PROJECT: MP 09_0146 MOD 4 - Modification to Eastlakes Shopping Centre
Mixed Use Development
RE: Response to Submissions 28.11.2019

Rory Toomey
Principal Design Excellence
Government Architect NSW

**18 EVANS AVENUE SOLAR STUDY  
LOWER BALCONY  
JUNE 21 EST SOLSTICE**

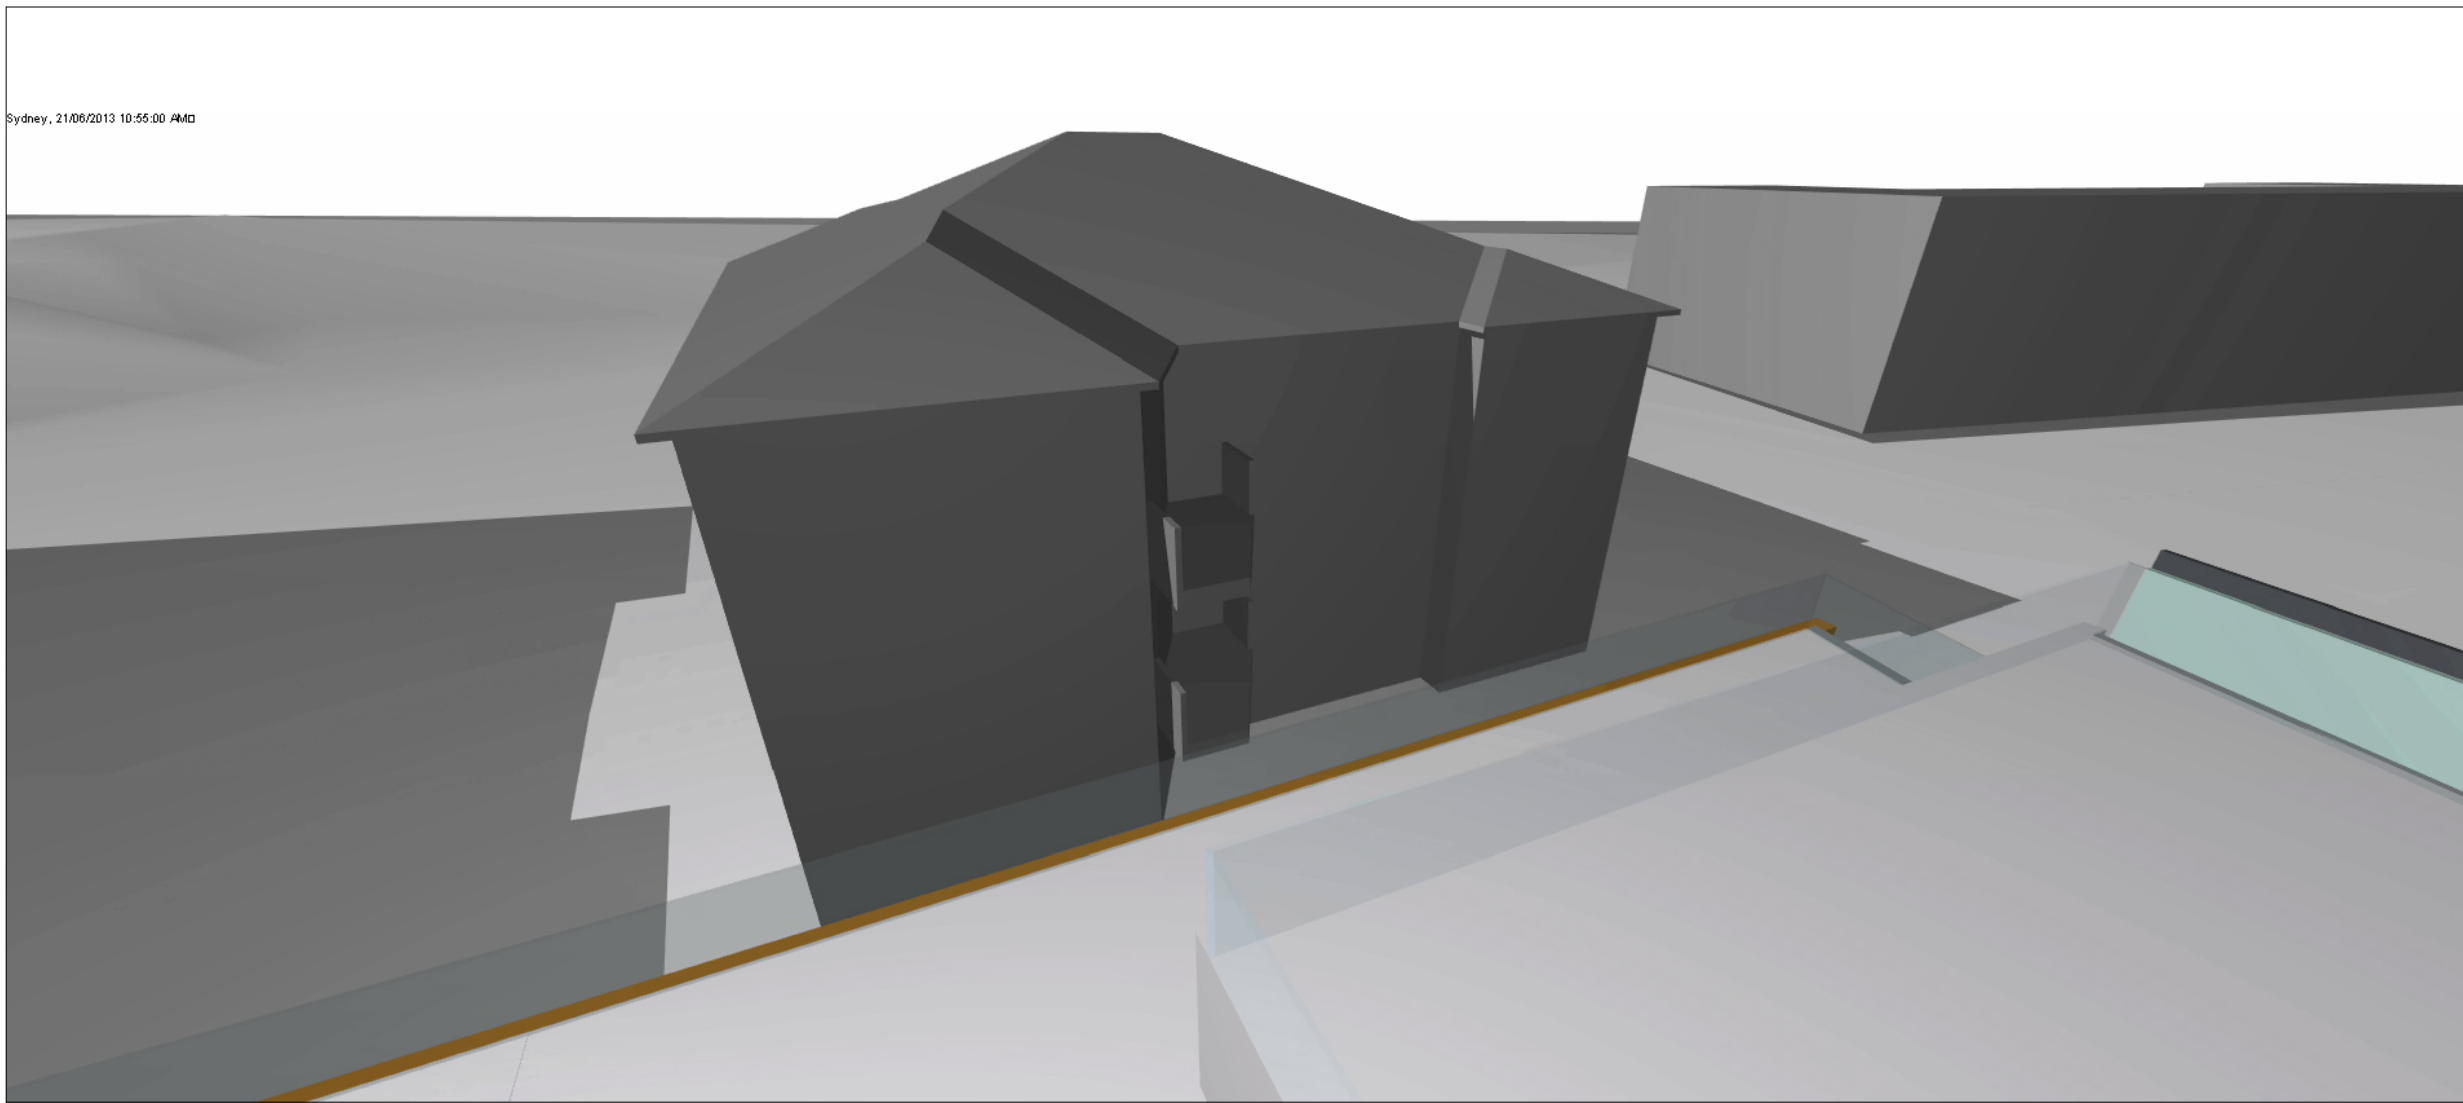
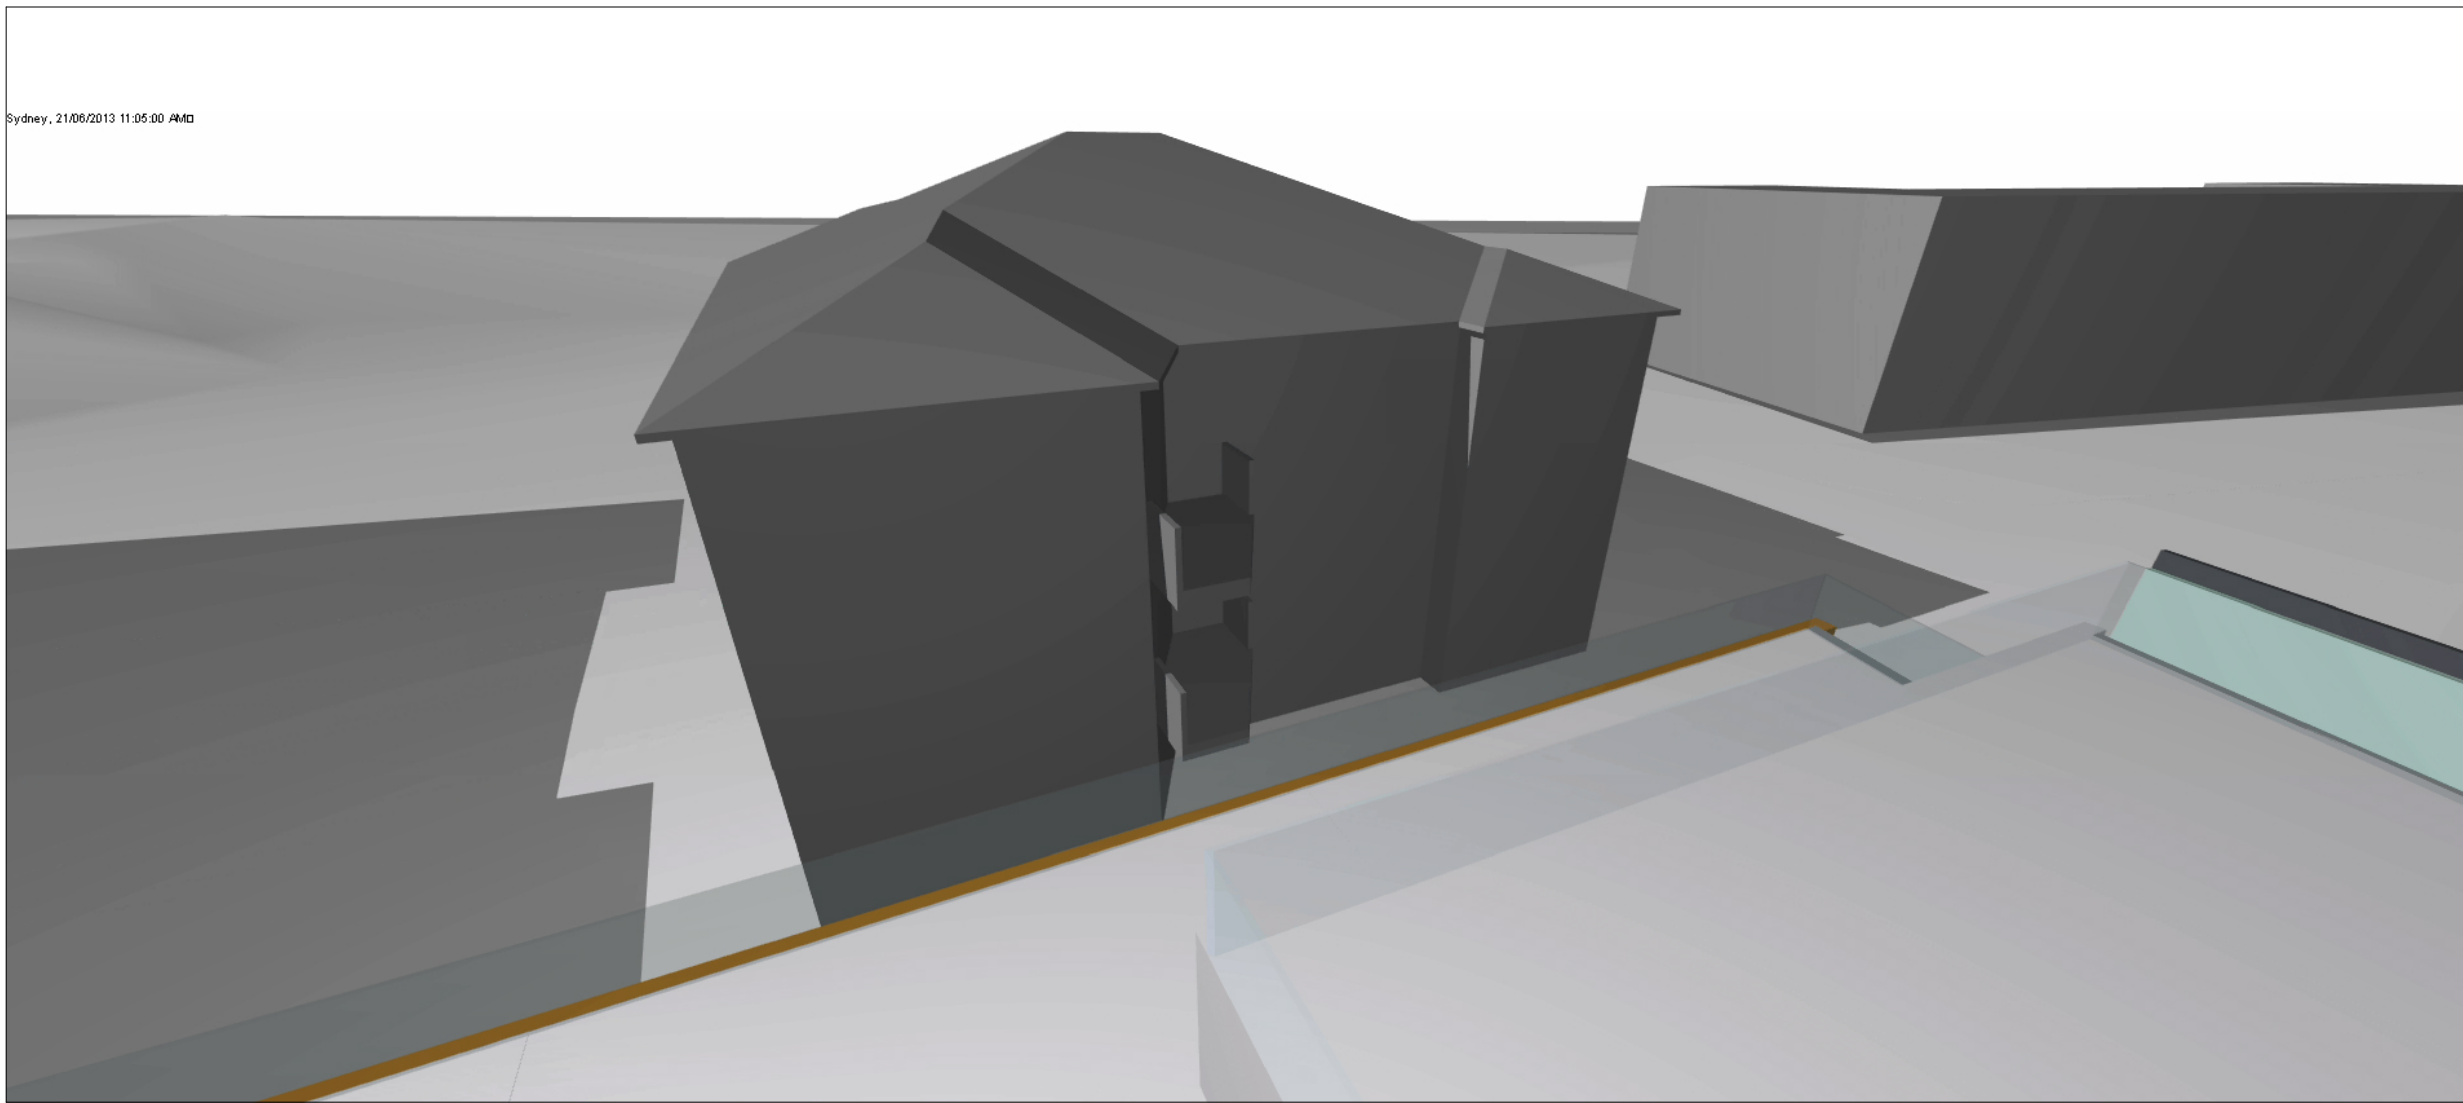
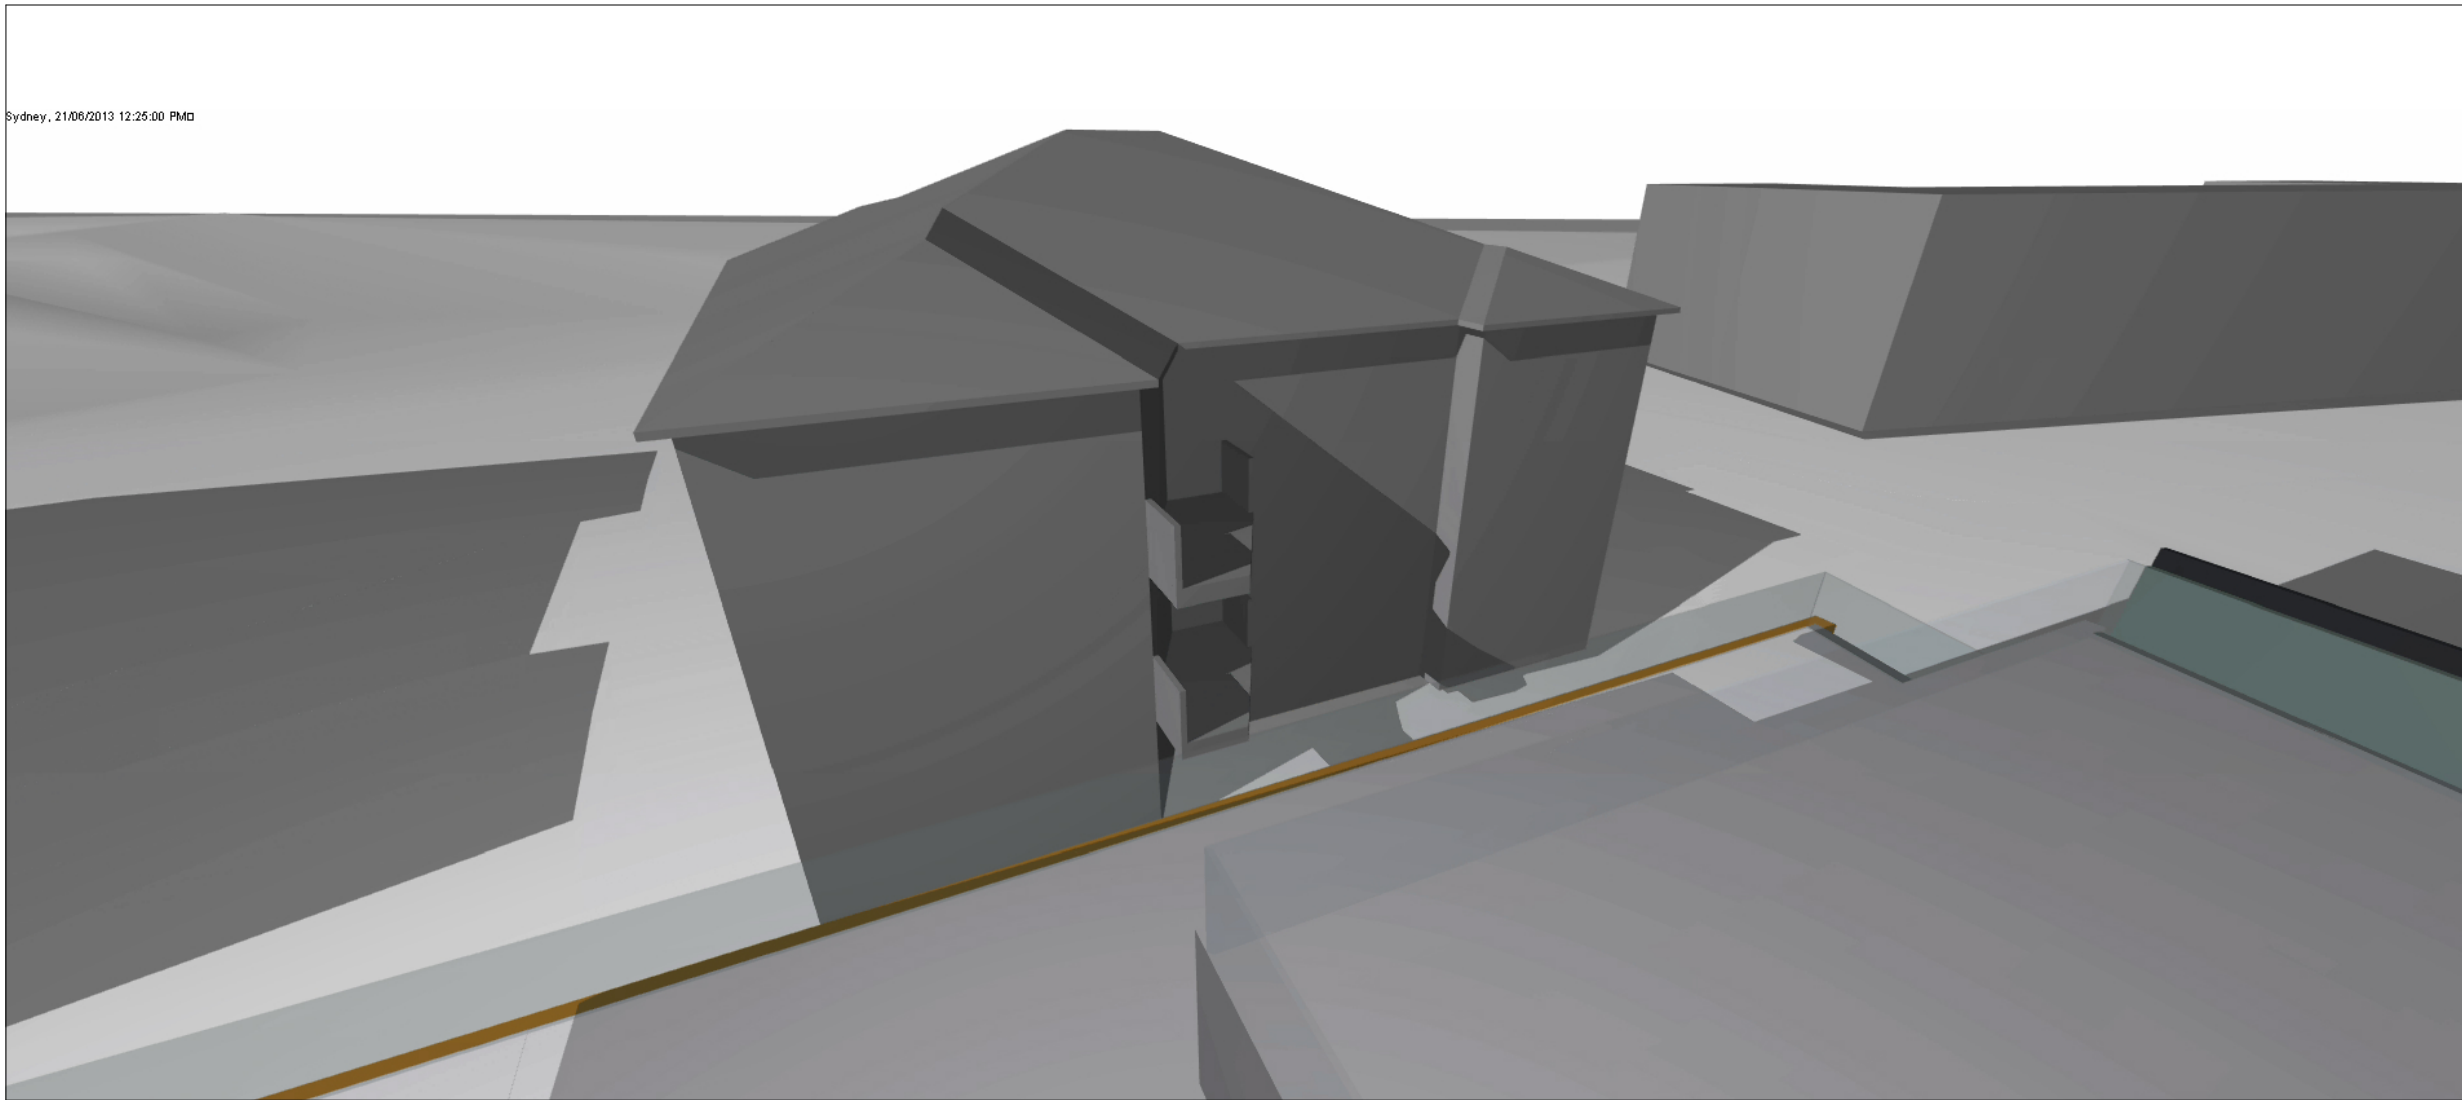
They demonstrated 2 hours of solar access to neighbouring properties and the treatment of the 'back of house' side of the project at street level is an improvement on earlier iterations.
